Response by Michael Brown to the SoS's letter dated 11th June 2026 inviting comments from Interested Parties on the Applicant's and others' responses to the SoS's RFI dated 14th April as amended on 20th and 28th April 2026

Comments on responses – using the paragraph numbering in the SoS 's RFI letter of 14th April as amended.

<b>Project:</b> AG1803	<b>Sheet:</b> Field 2.79
<b>Date:</b> November 2024	
<b>Scale:</b> 1 : 3000 @A3

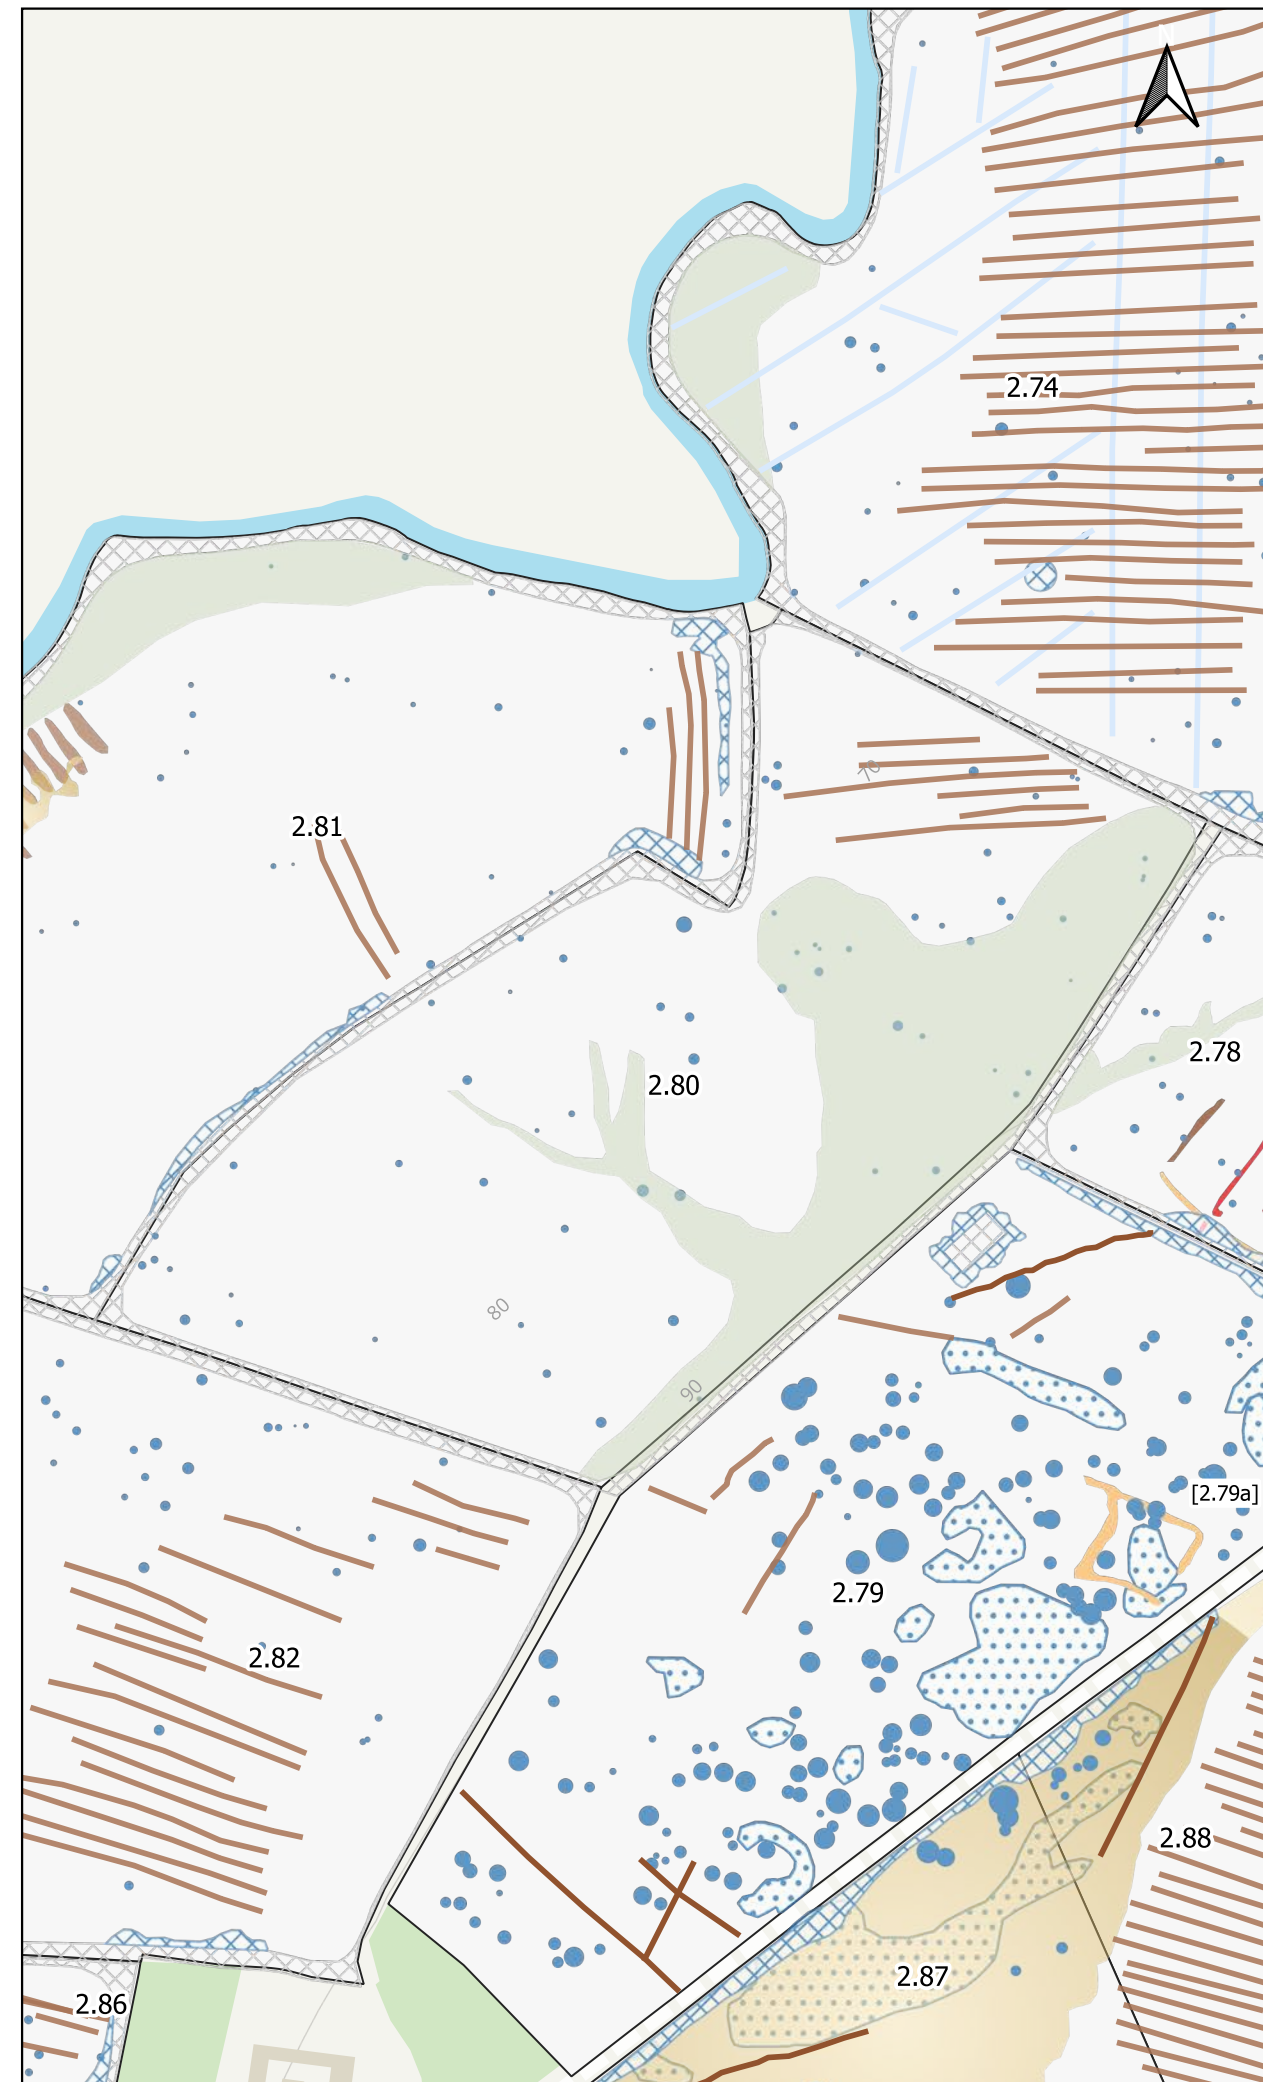
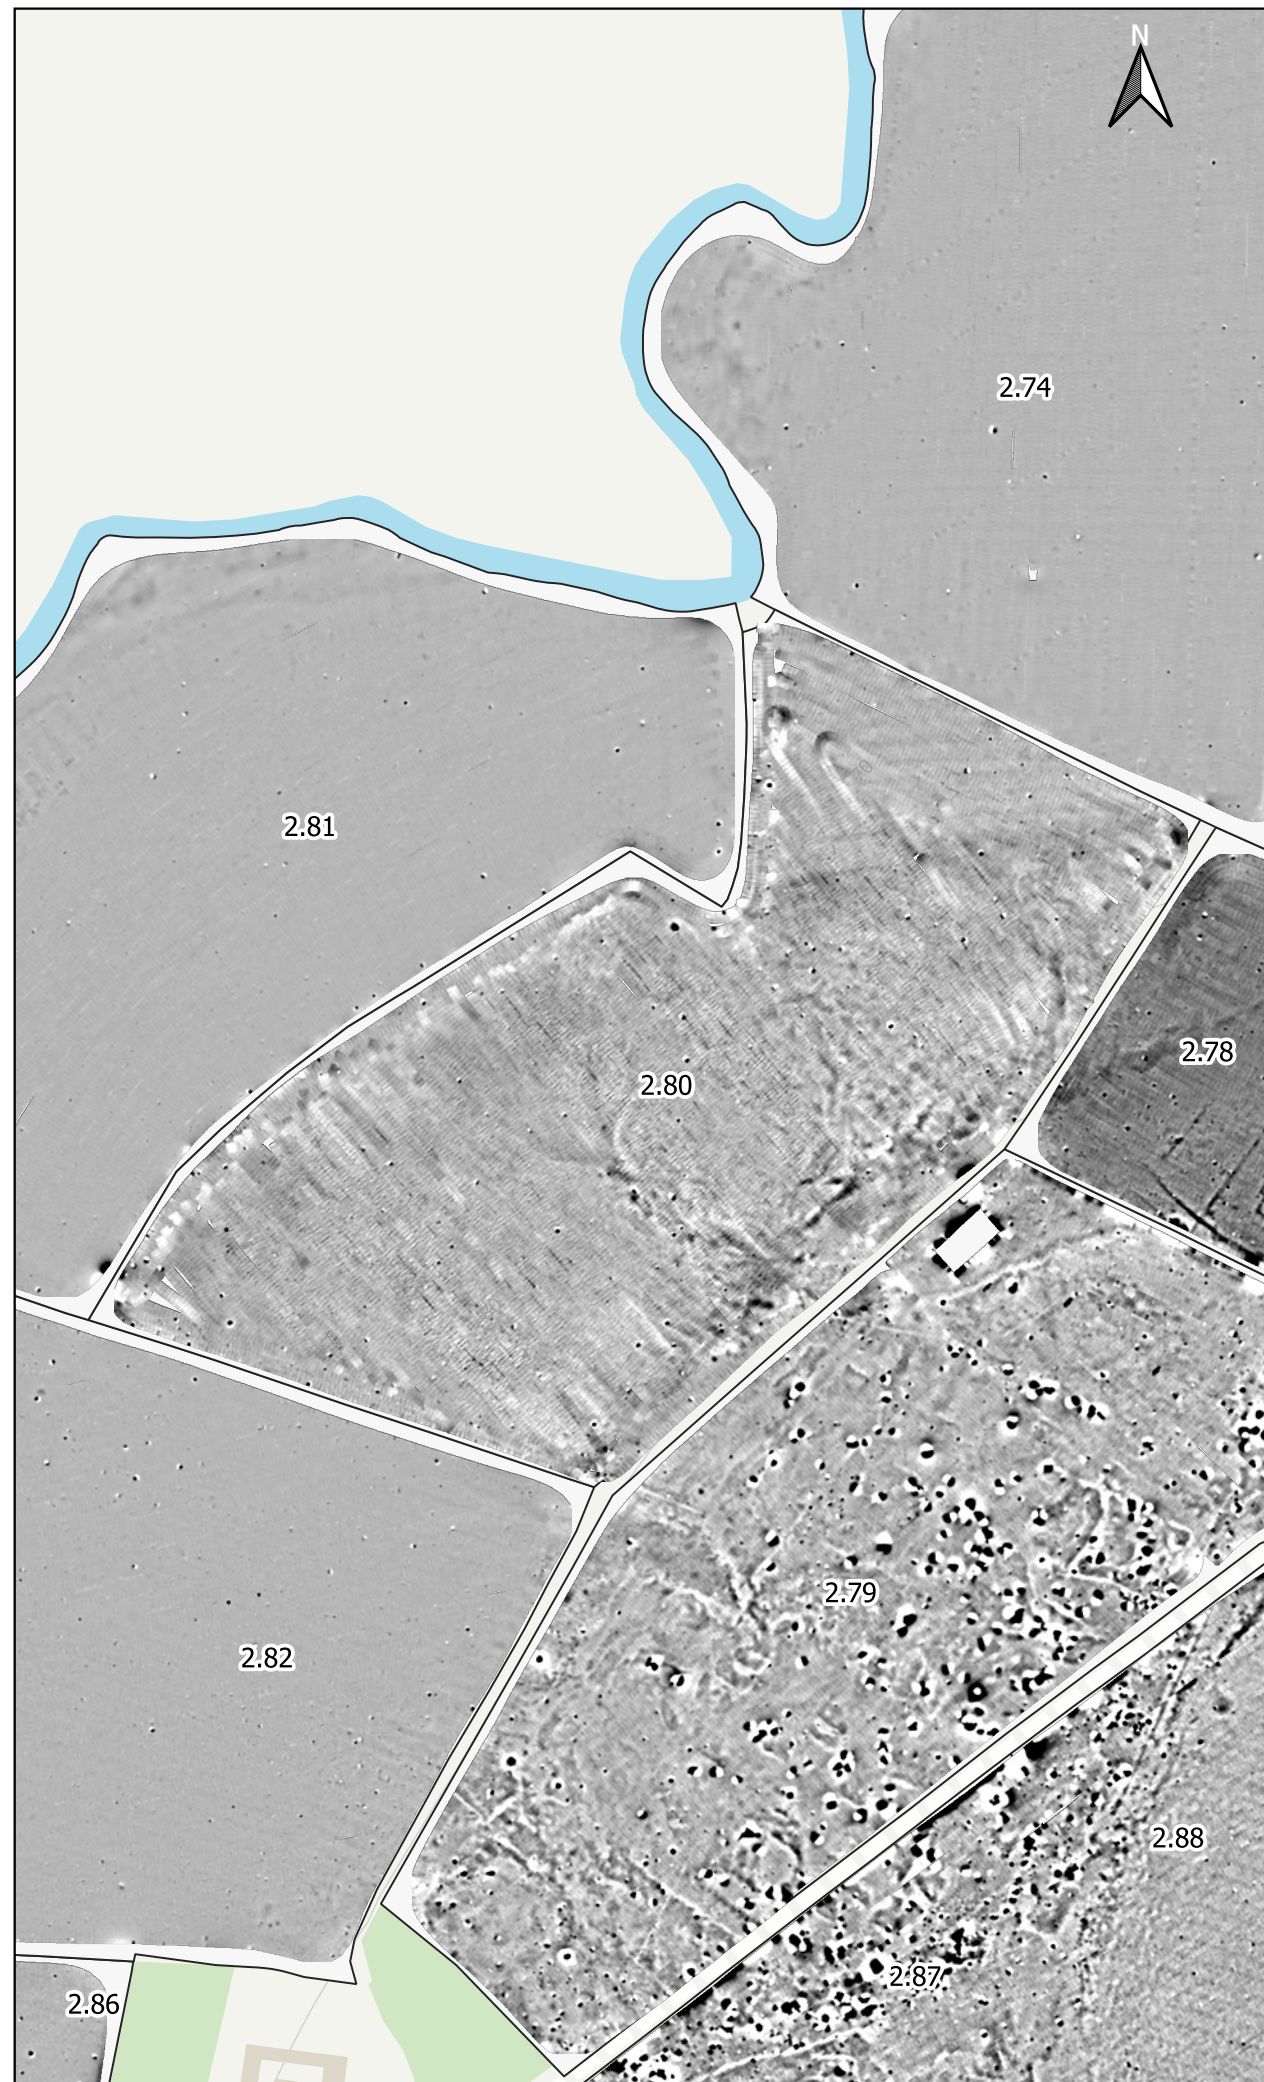
The Applicant also refers to '*Topography- panels on rising land/hillsides*', but avoids any reference to the rising land/hillsides on the eastern side of the Evenlode valley. The latest Illustrative Masterplans 2.2D and 2.2F (C1-051) show fields full of panels along the rising land/hillsides and even breaking the skyline from our house. These fields include numbers: 2.79, 2.80, 2.82, 2.89, 2.94 and 2.105.

Also under '4.2 Avoid' the Applicant asserts that its avoidance measures include the '*exclusion of ridgeline zones identified during the LVIA process*'. On this basis at least Field number 2.79, which we see from our house, should have been removed. It has not, and is still shown covered with panels on Illustrative Masterplan Rev.4 – 2.2D.
